Our ref: OUT22/19025

Subject: McPhillamys Gold Project (SSD-9505) – Response to DPE Water advice on Submissions Report, Amendment Report and additional information

Detailed advice to DPE Planning & Assessment regarding the McPhillamys Gold Project (SSD-9505) – Response to DPE Water advice on Submissions Report, Amendment Report and additional information

# DPI (2013) VERIFIED STREAM ORDER

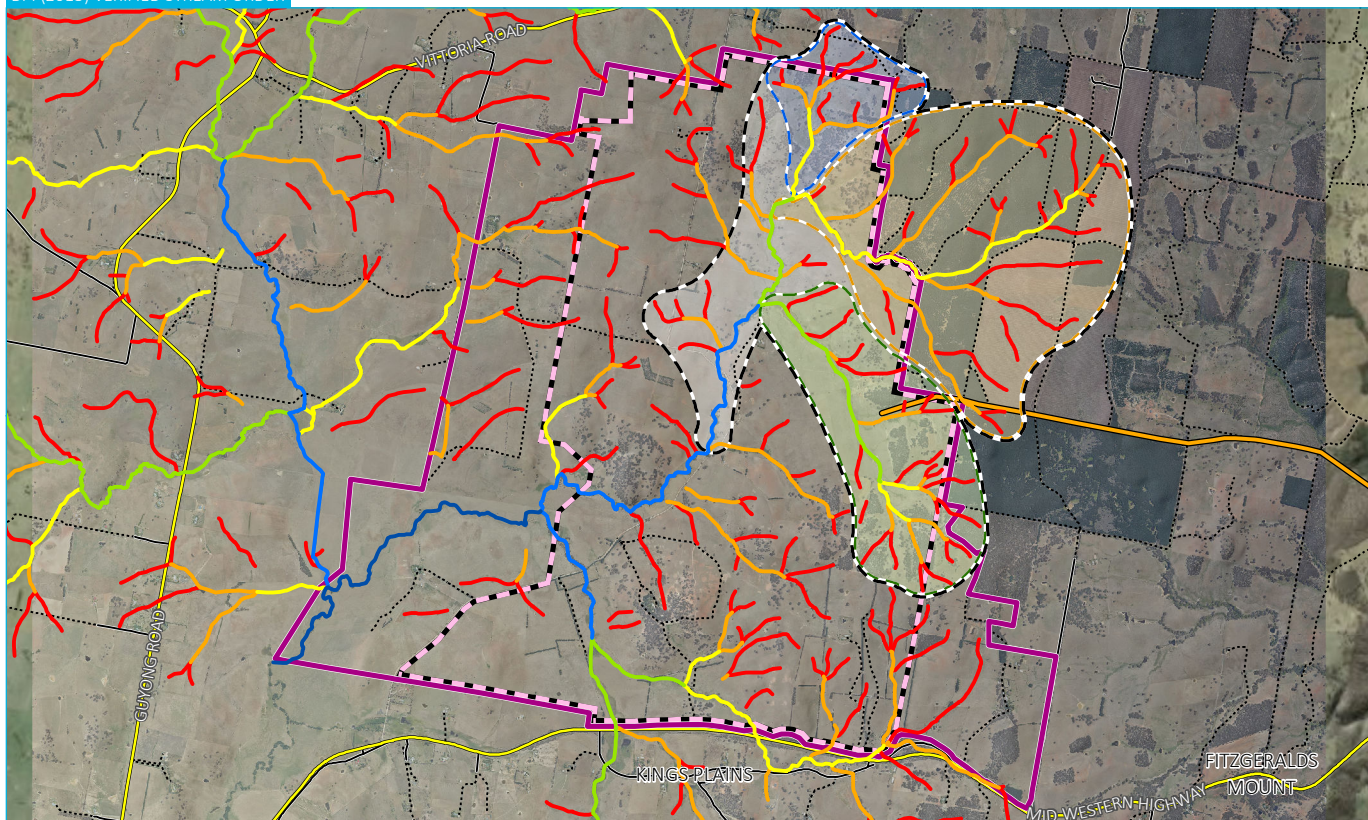
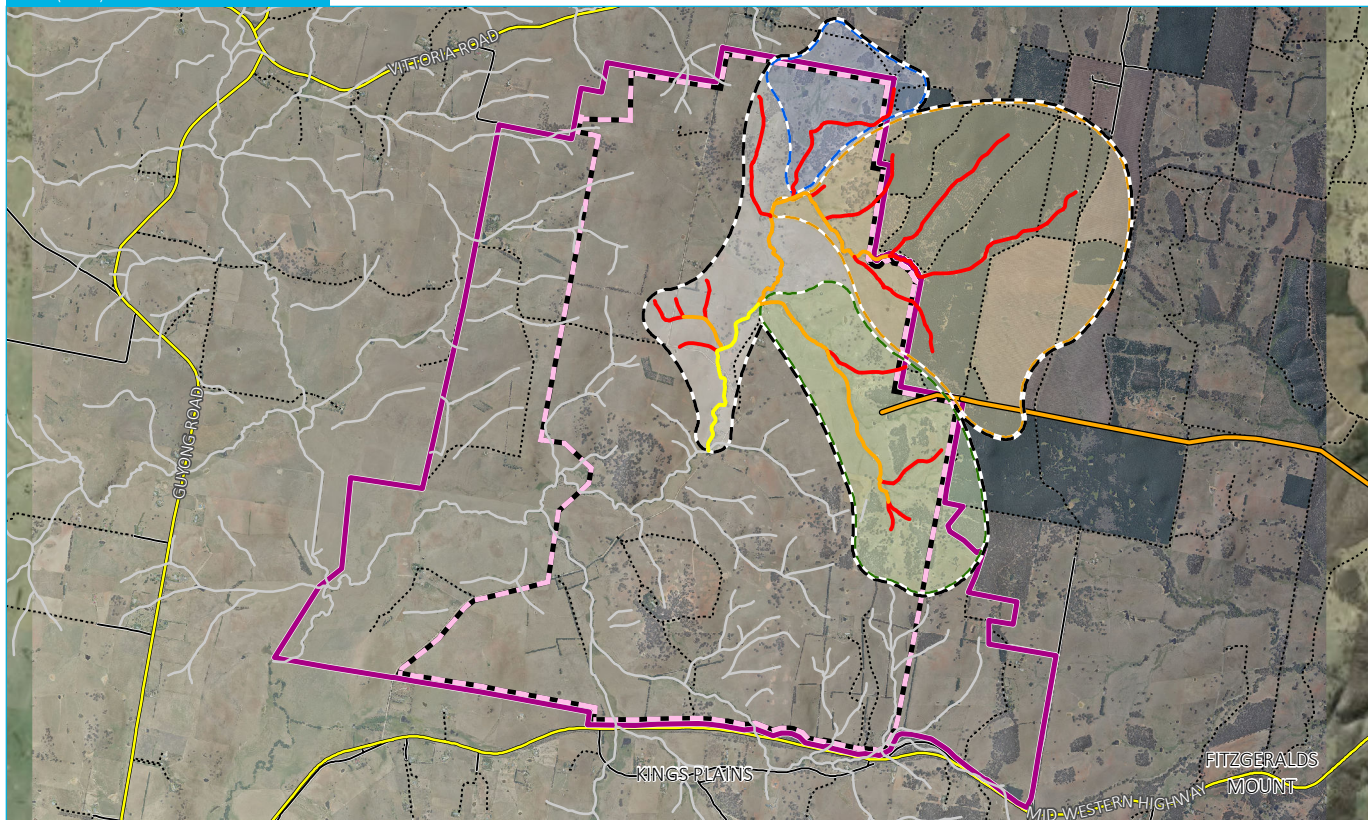
The proponent should quantify the maximum water take from the 4th order watercourse near the proposed waste rock emplacement that was referred to in DPE Water’s response dated 14 July 2022 (OUT22/7739). This volume would need to be included in a SPAL application, in addition to any water take from all 3rd or higher order streams or from works that do not meet an exemption or exclusion.

The response did not clearly address the previous request in relation to the 4th order watercourse and the proponent may be relying on an updated hydroline layer to apply licence exclusions for minor streams. As an updated hydroline layer is yet to be implemented it is recommended the proponent determine licensing requirements based on the hydroline layer on DPE Water’s website at the time of application.
